Your Ref: OWPC24022
Our Ref: AL/59/19/HH
Please ask for:
Amber Willard

14th August 2019

Two storey front extension, two storey side extension and single storey rear extension
Stanwick Northfields Lane Westergate

Thank you for your internet comments made on 13th August 2019 which has been recorded as **'an objection'** with the comments as follows:

Proposed Front Elevation

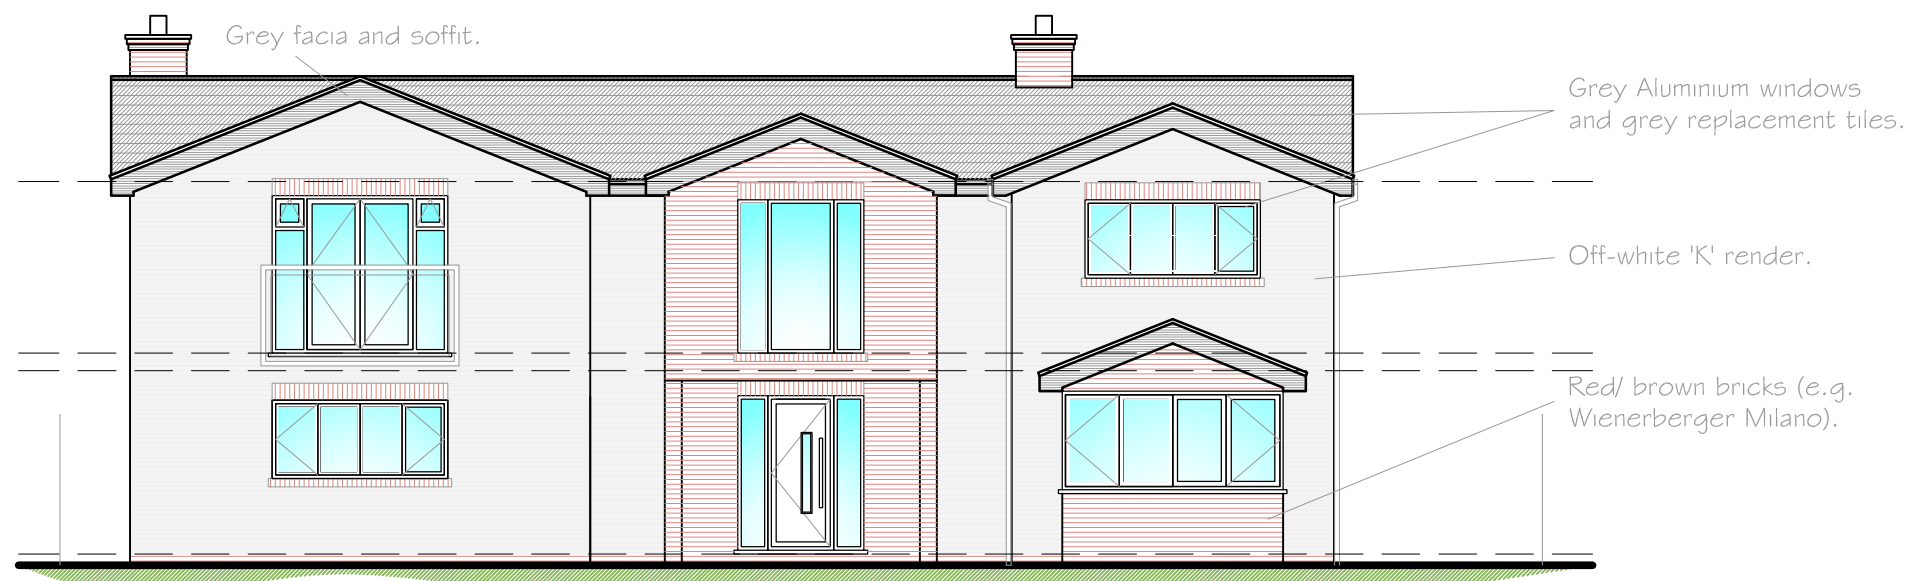
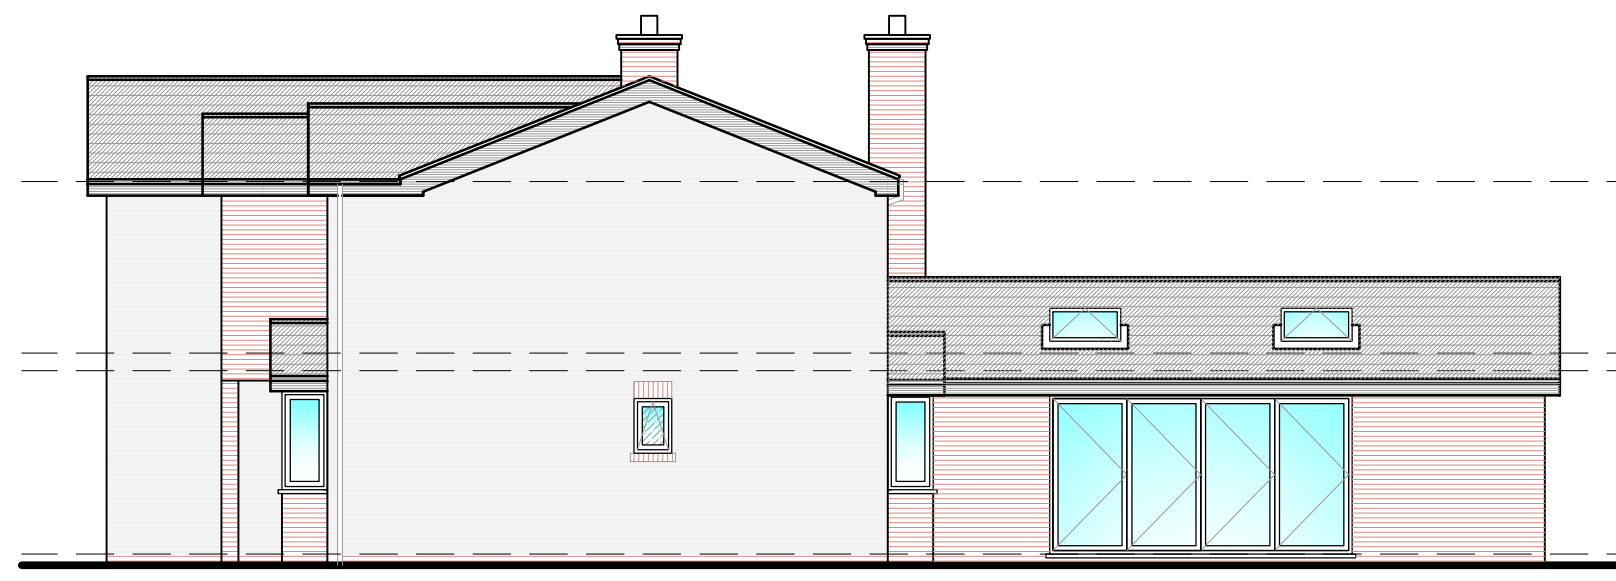
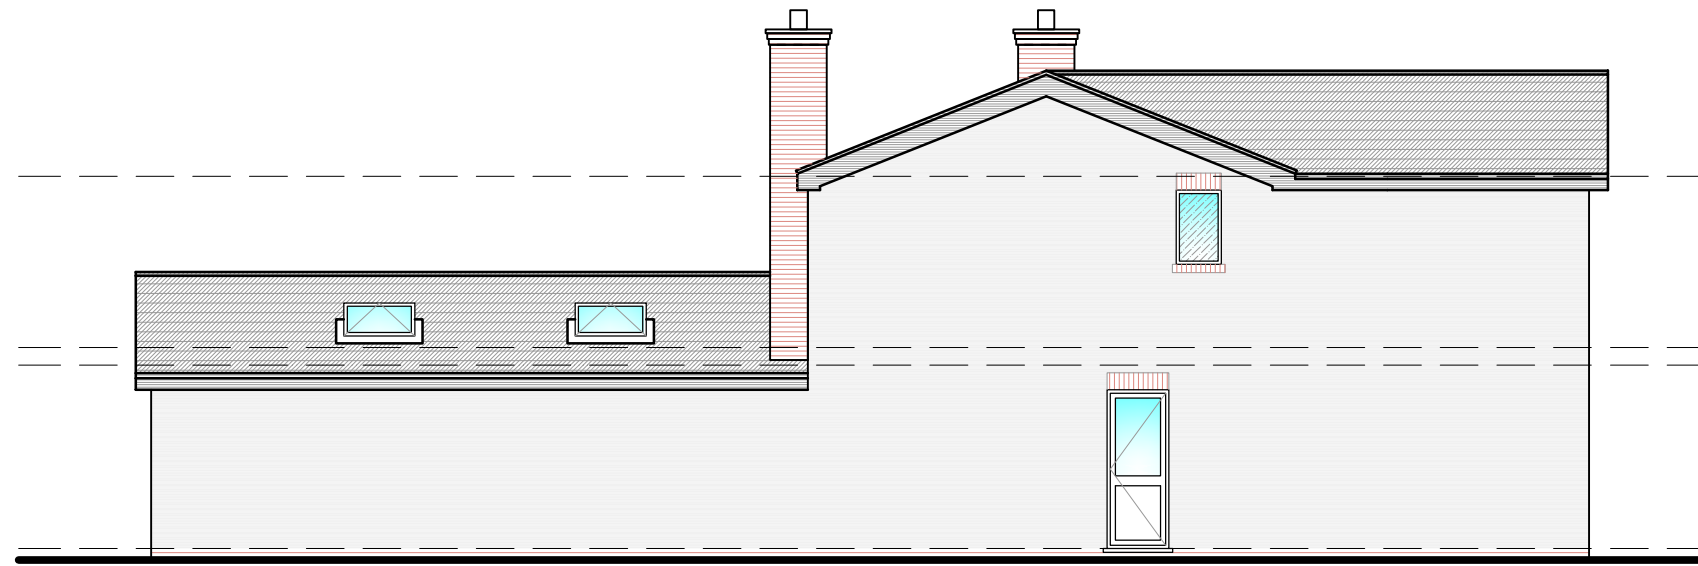
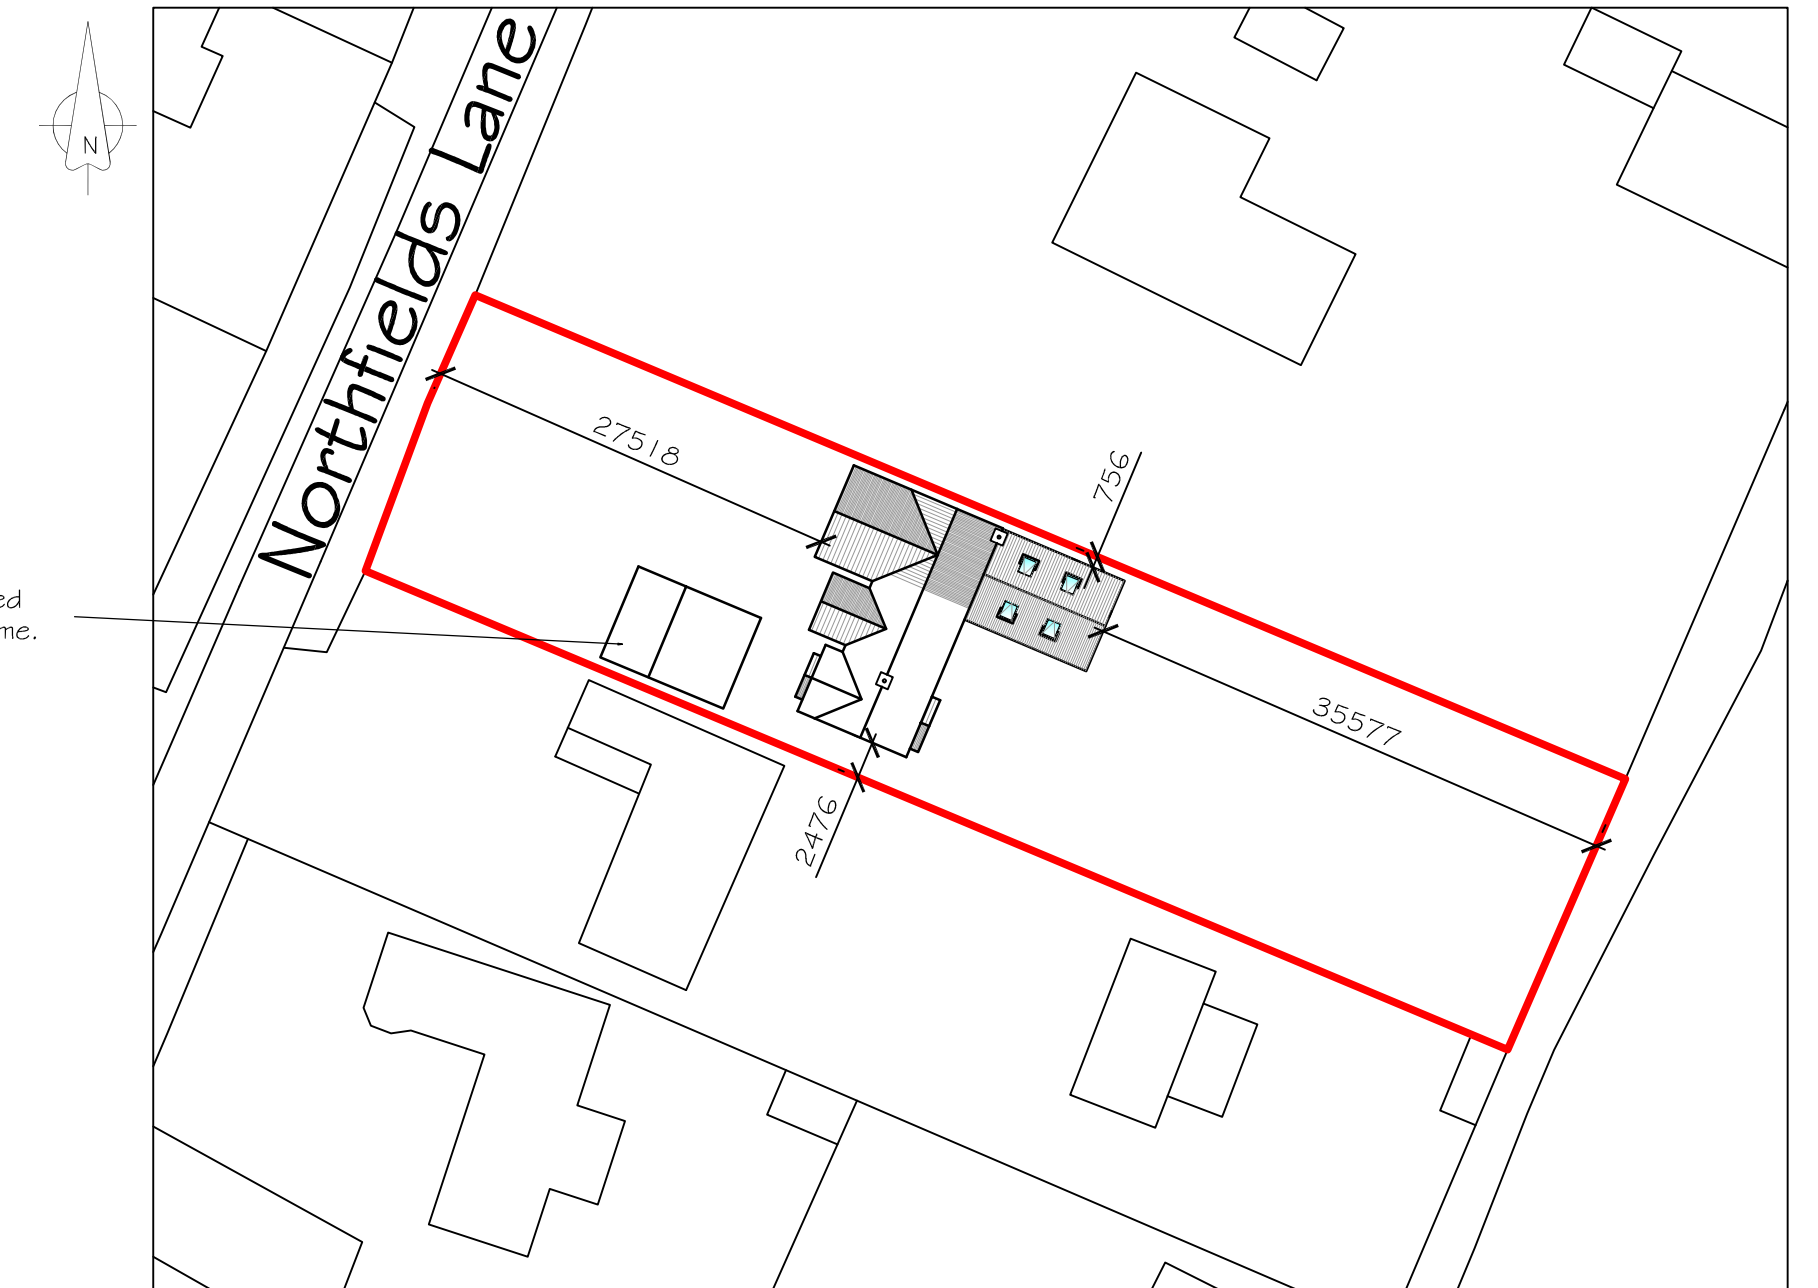
The Council notes it's objection on the basis that there are concerns regarding proposed design quality and that it doesn't match with local character - it is therefore not compliant with Aldingbourne's Neighbourhood Plan Policy H1. Additionally, the Council considers there are possible impacts on drainage and, hence, that it may not meet requirements of Policy EH5 regarding surface water management.
